Our Case Number: ACP-324568-26

Re: Proposed Development of the Barnesmore Gap Greenway Project
County Donegal

**Letter of Observation / Submission to An Bord Pleanála
Barnesmore Greenway Application and CPO**

Case Number: ACP-324568 Date: 30 September 2026

S02 - UNDERPASS PLAN

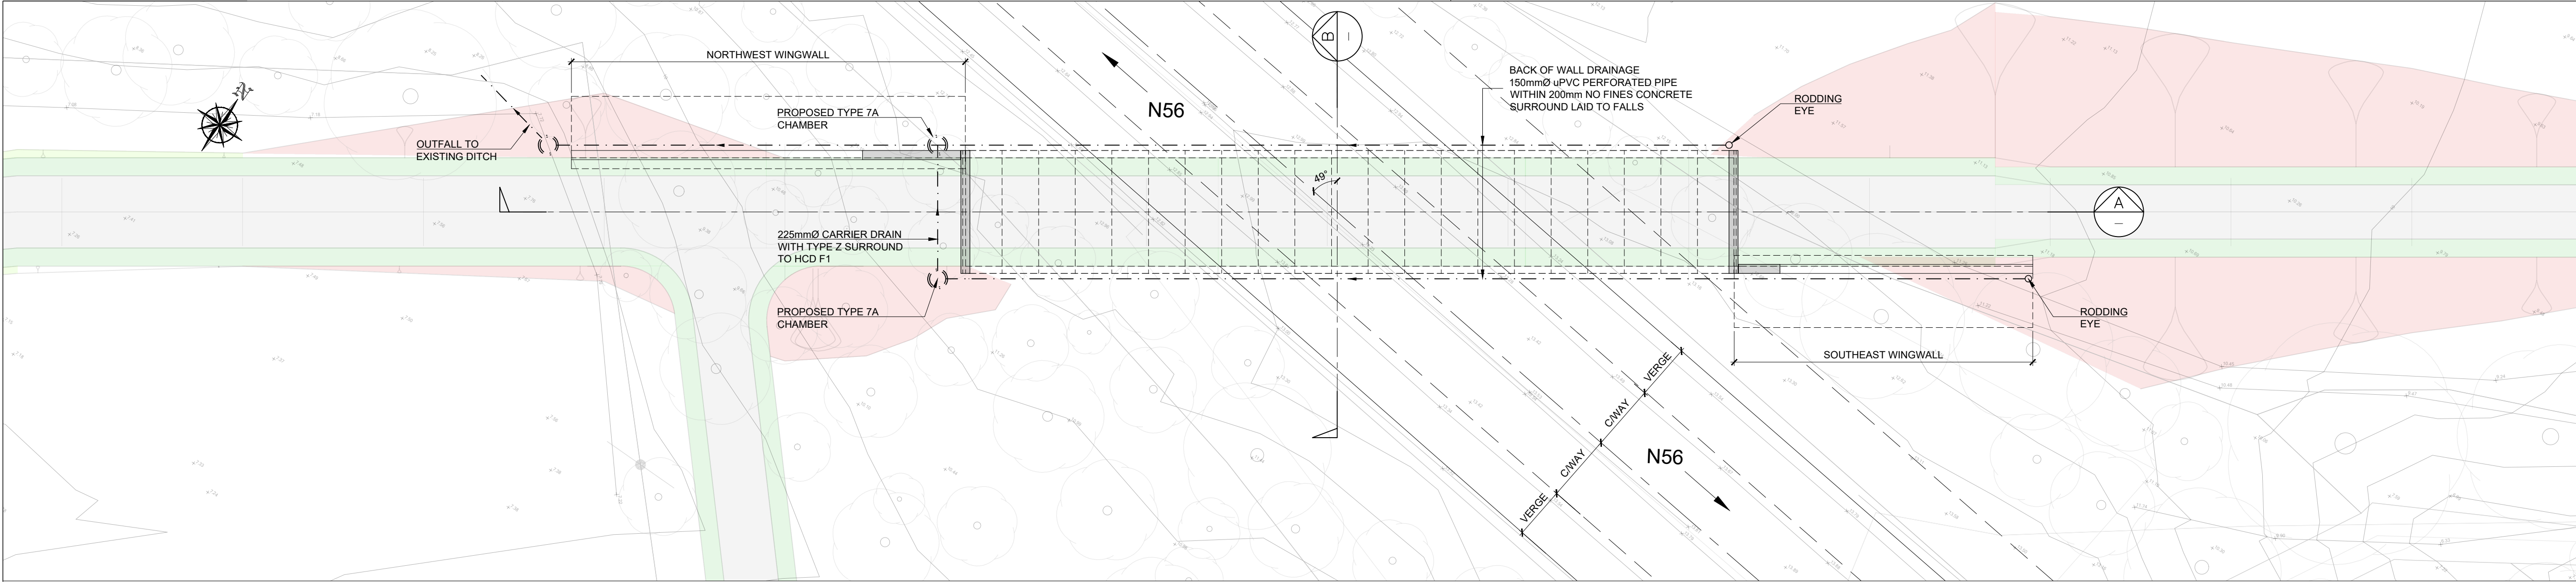
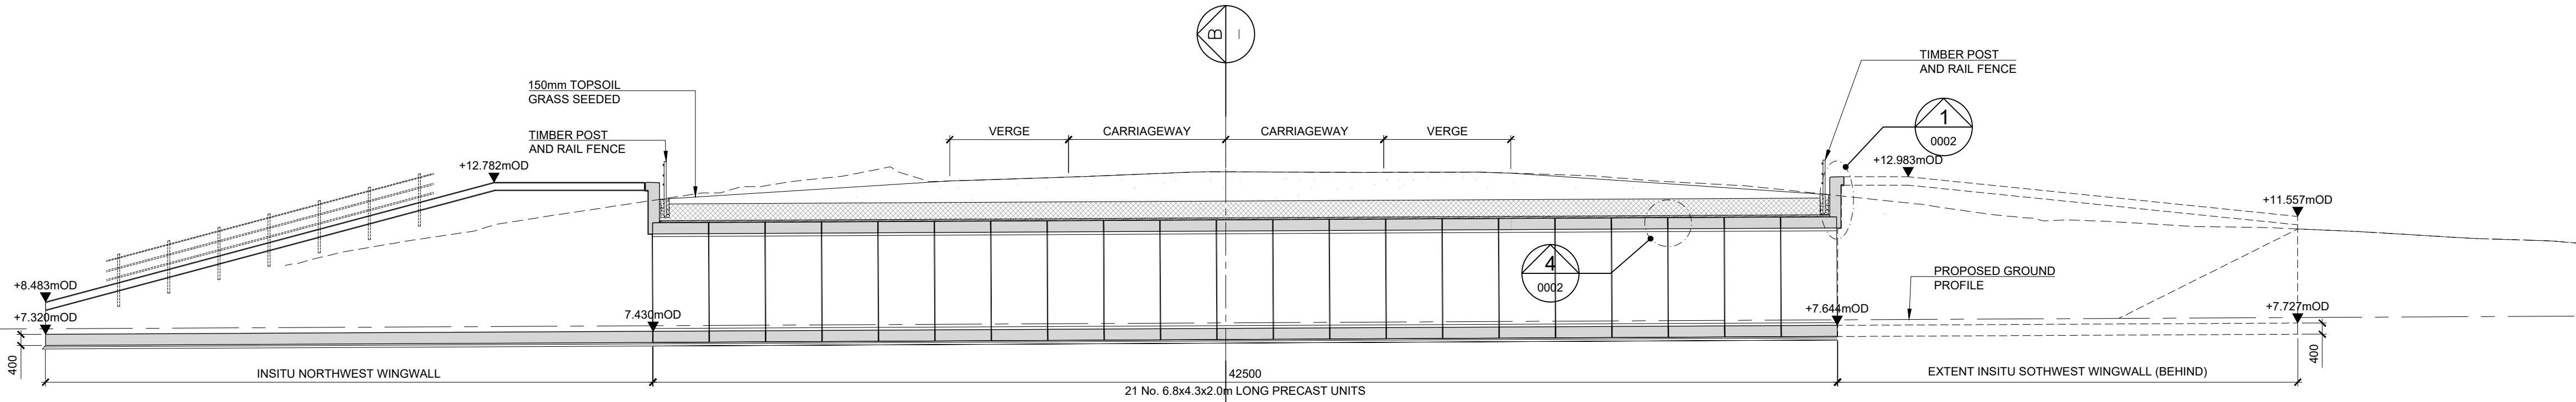
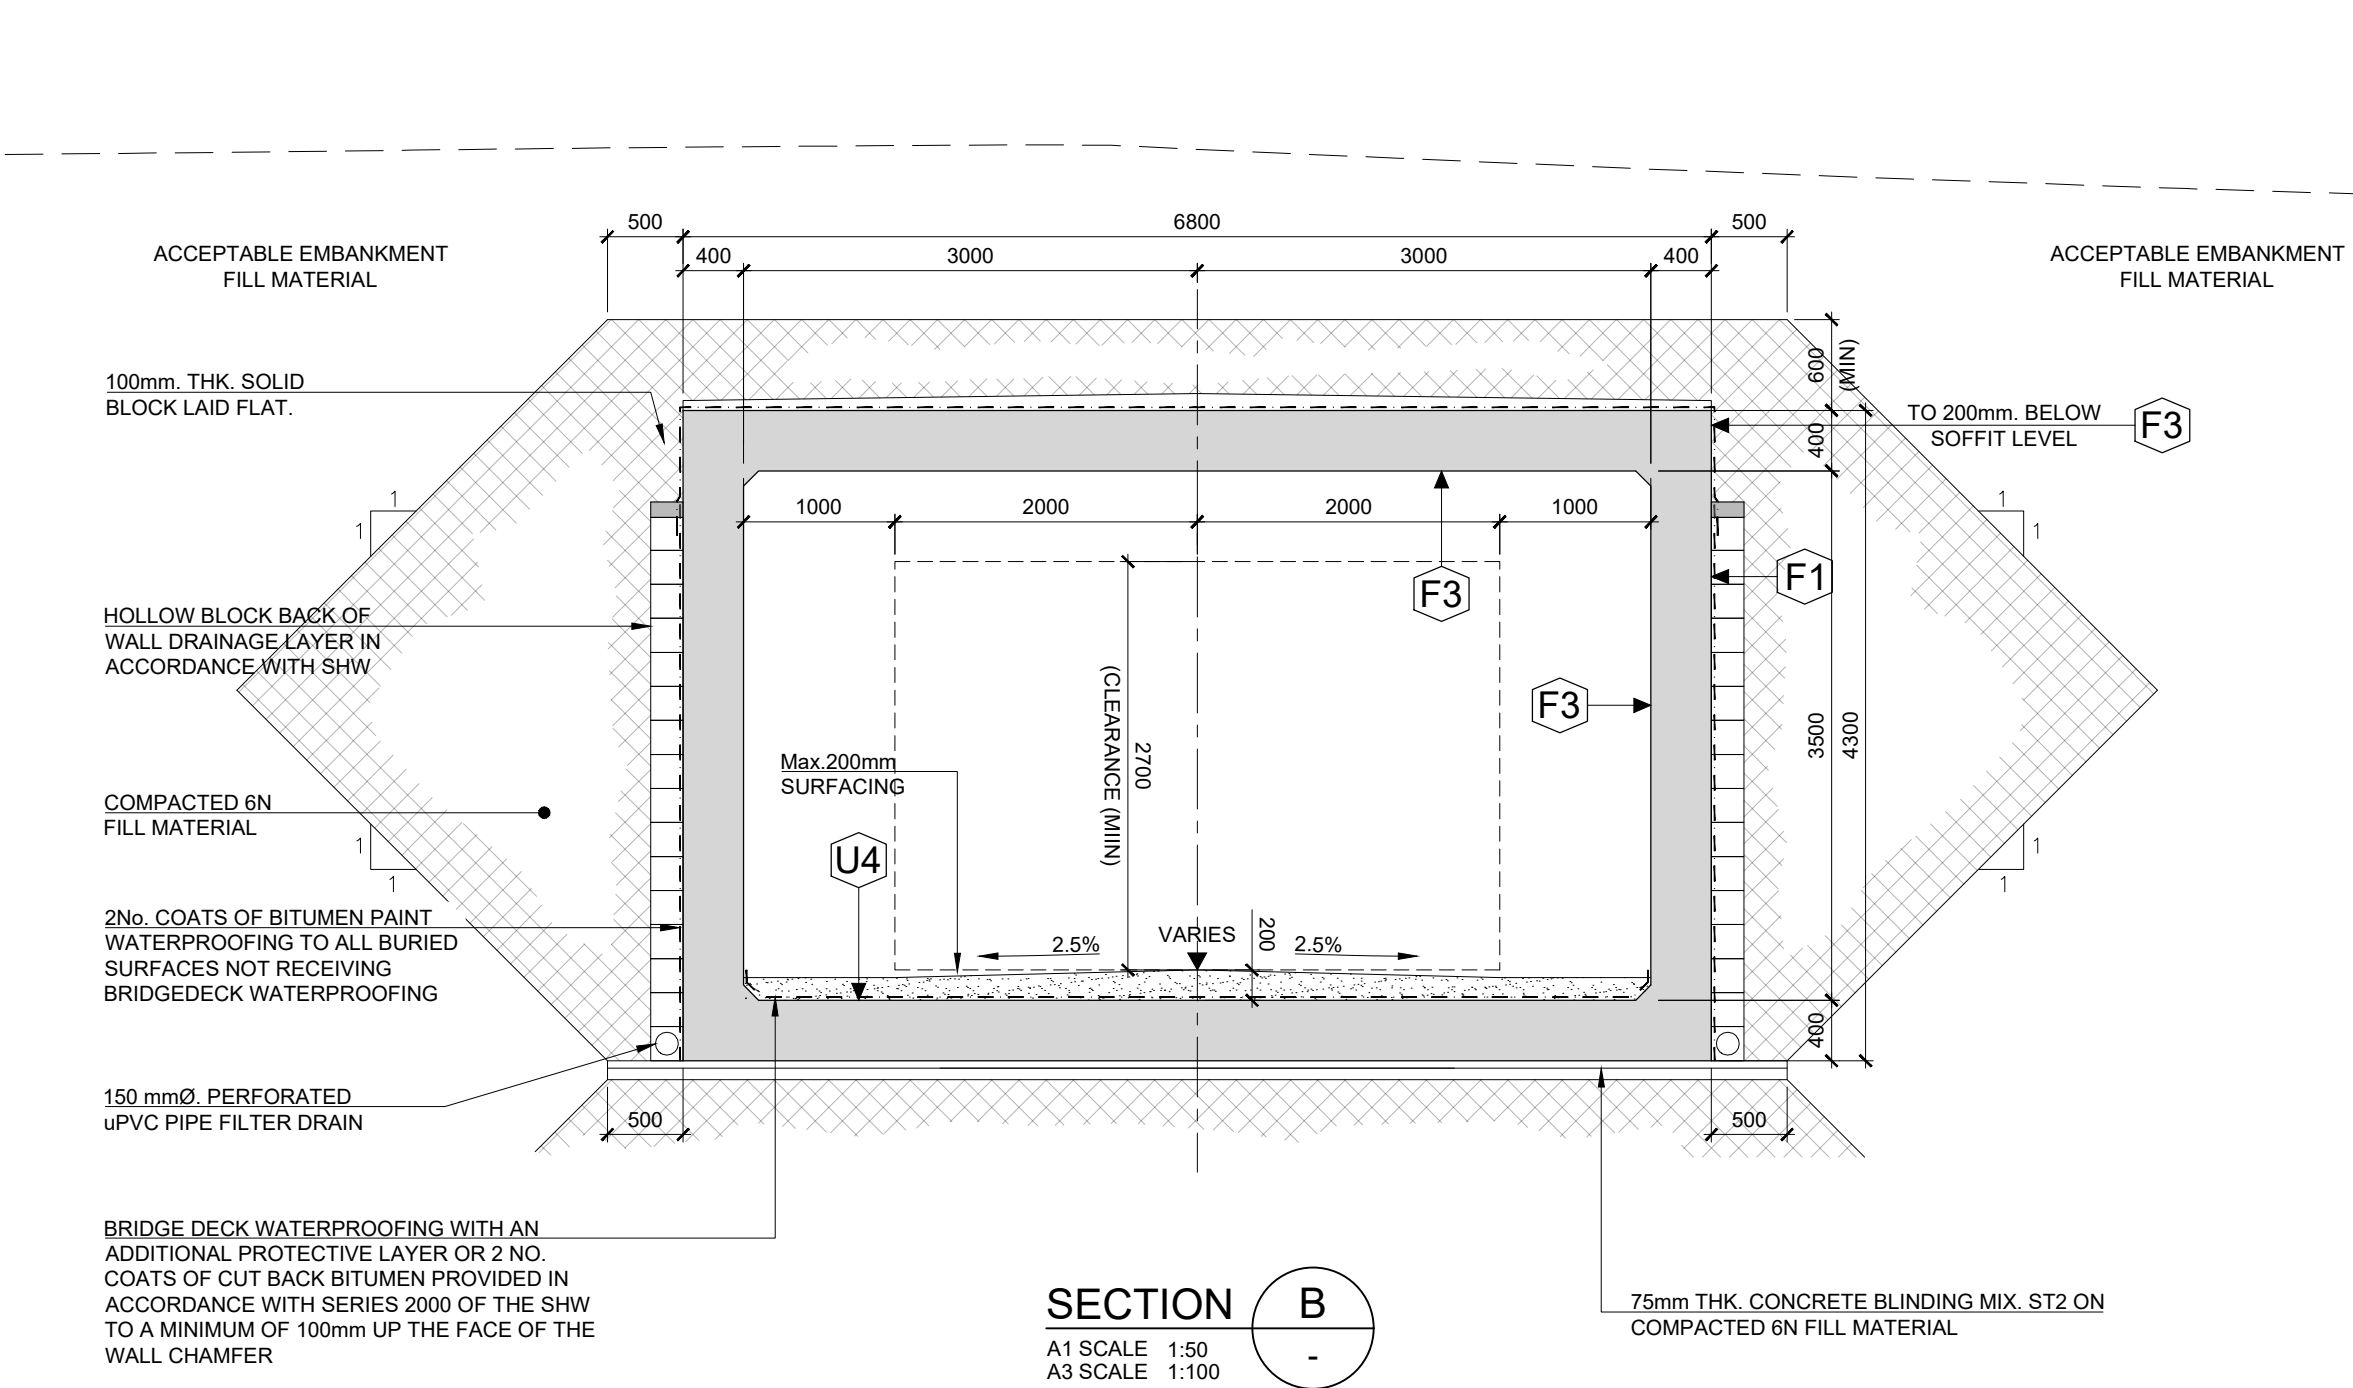
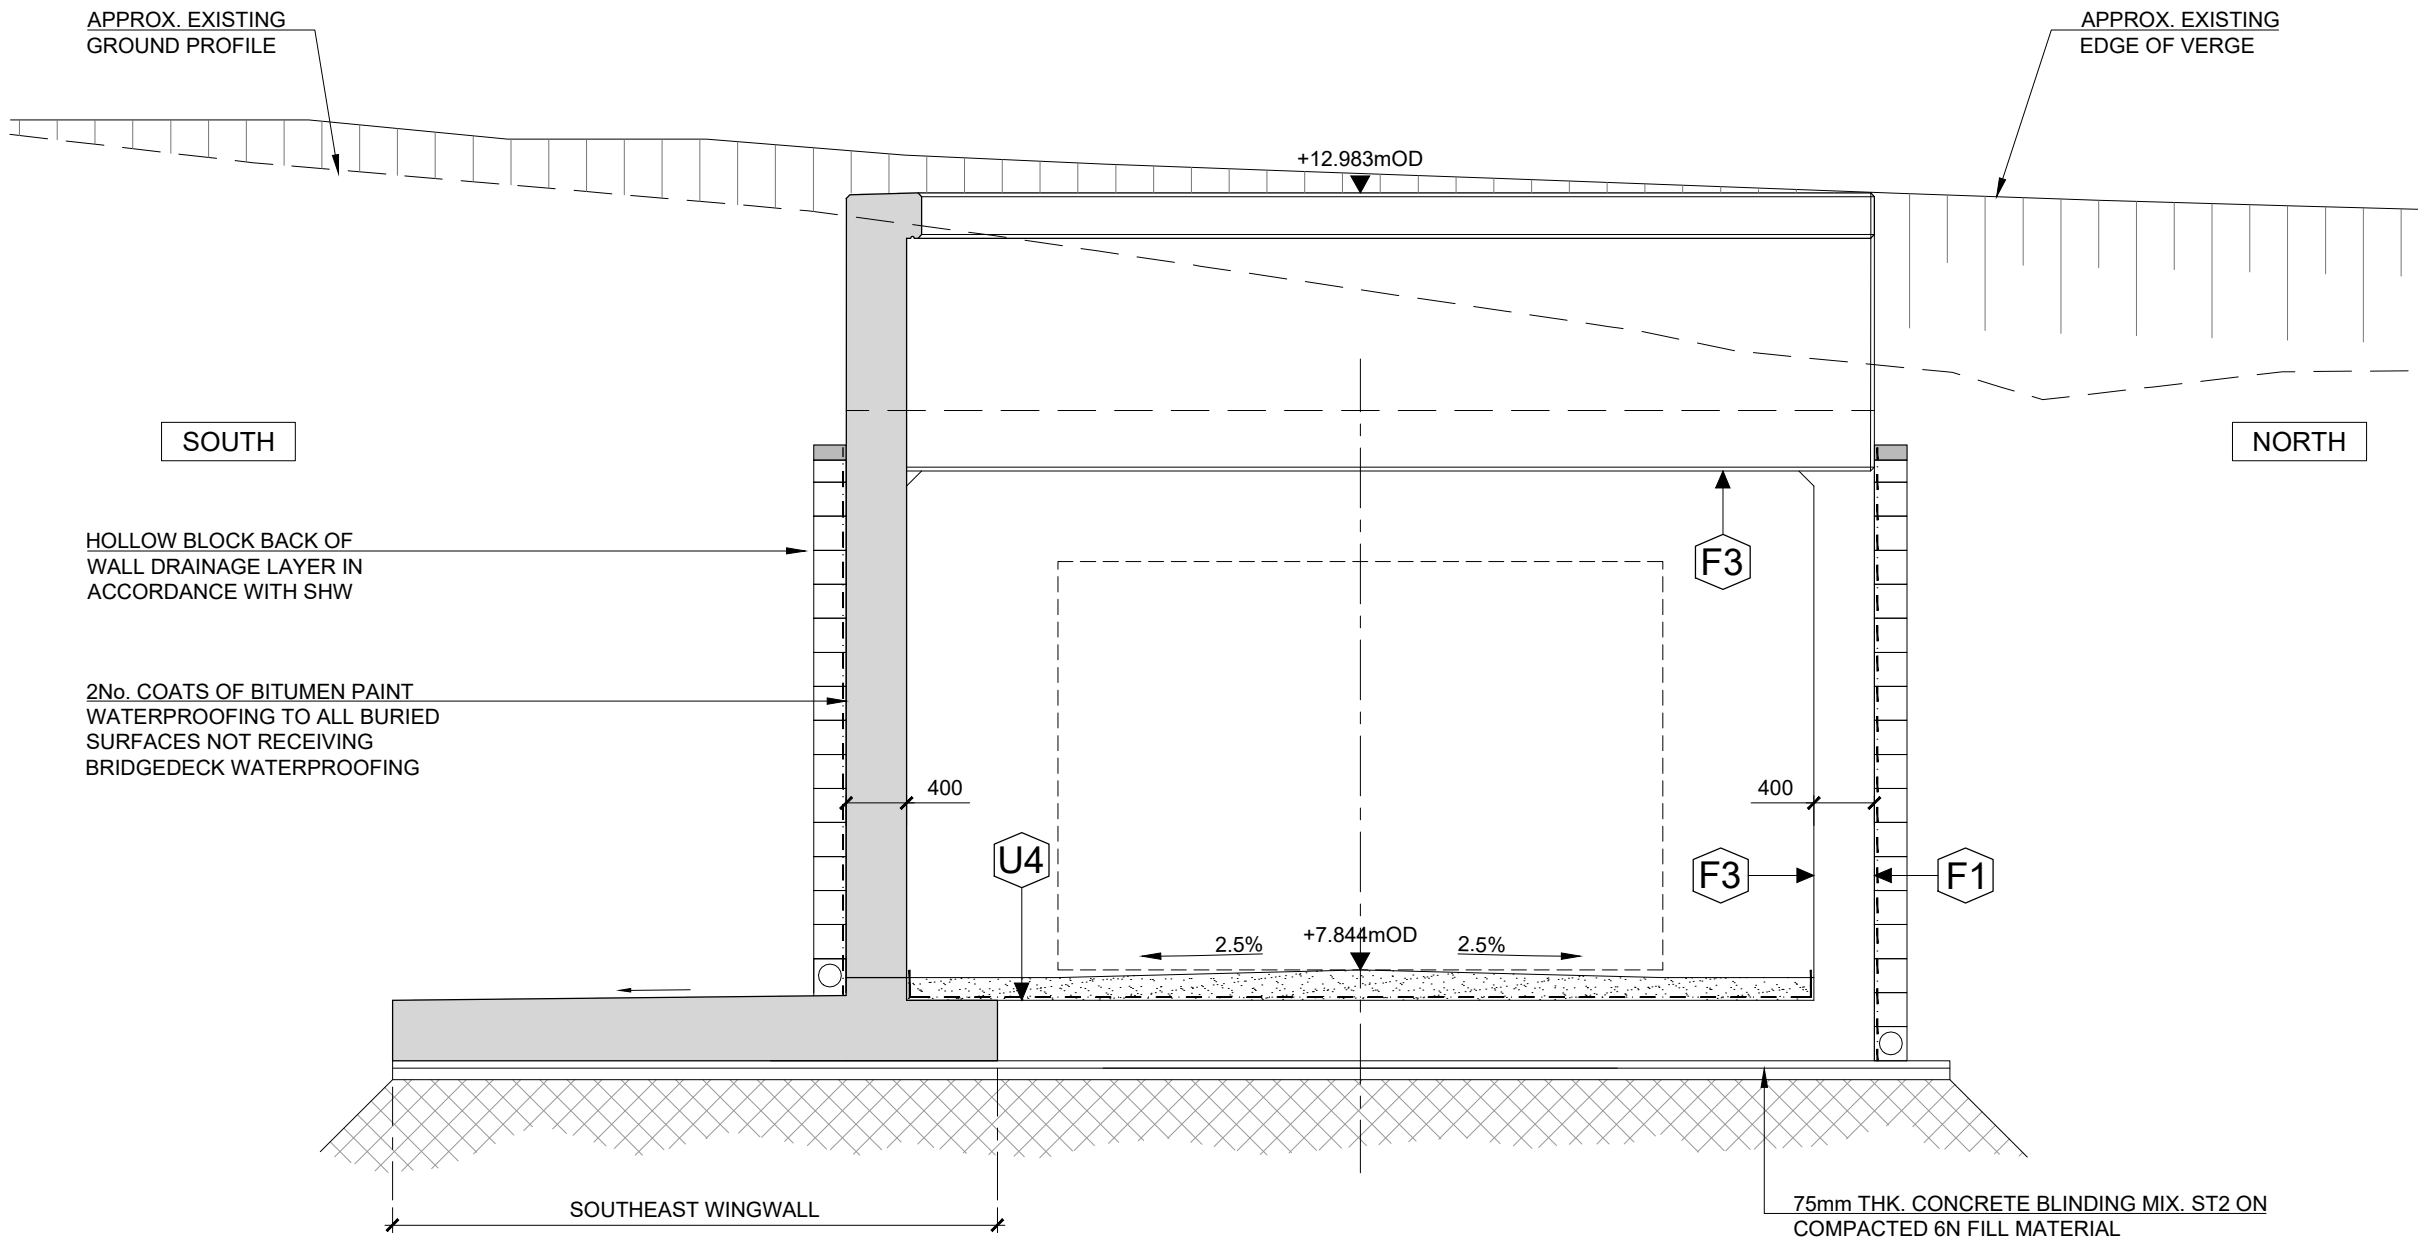
2. Location of the Greenway and Underpass S02

The location of the S02 underpass and associated greenway corridor across my late father's landholding has already been fixed as part of the Phase 2 design submitted to An Bord Pleanála. The EIAR treats both the underpass and the greenway alignment as established, engineered elements of the scheme, with their siting, gradients, land-take and structural tie-ins fully assessed and locked into the statutory environmental documentation.

The proposed underpass will physically separate the land from adjoining lands zoned as an Opportunity Area. This represents a material and permanent change to the structure of the landholding. The separation will significantly reduce the functional relationship between the parcels and diminish the strategic value that originally justified the acquisition of the land.

The footprint of the underpass, approach ramps and drainage basins will materially reduce the usability, coherence and amenity of the remaining lands. This severance will have a lasting impact on the functional and practical use of the property.

The proximity of the underpass to the remainder of the land will result in permanent changes to noise levels, visual outlook, privacy and general amenity. These impacts will endure for the lifetime of the structure and will materially affect the value and enjoyment of the property. These matters will be discussed with the Council in due course.

The proposed works introduce a significant engineering burden, including retaining structures, excavation, embankments and long-term maintenance zones. These elements will permanently alter the character and usability of the land and impose constraints that would not otherwise exist.
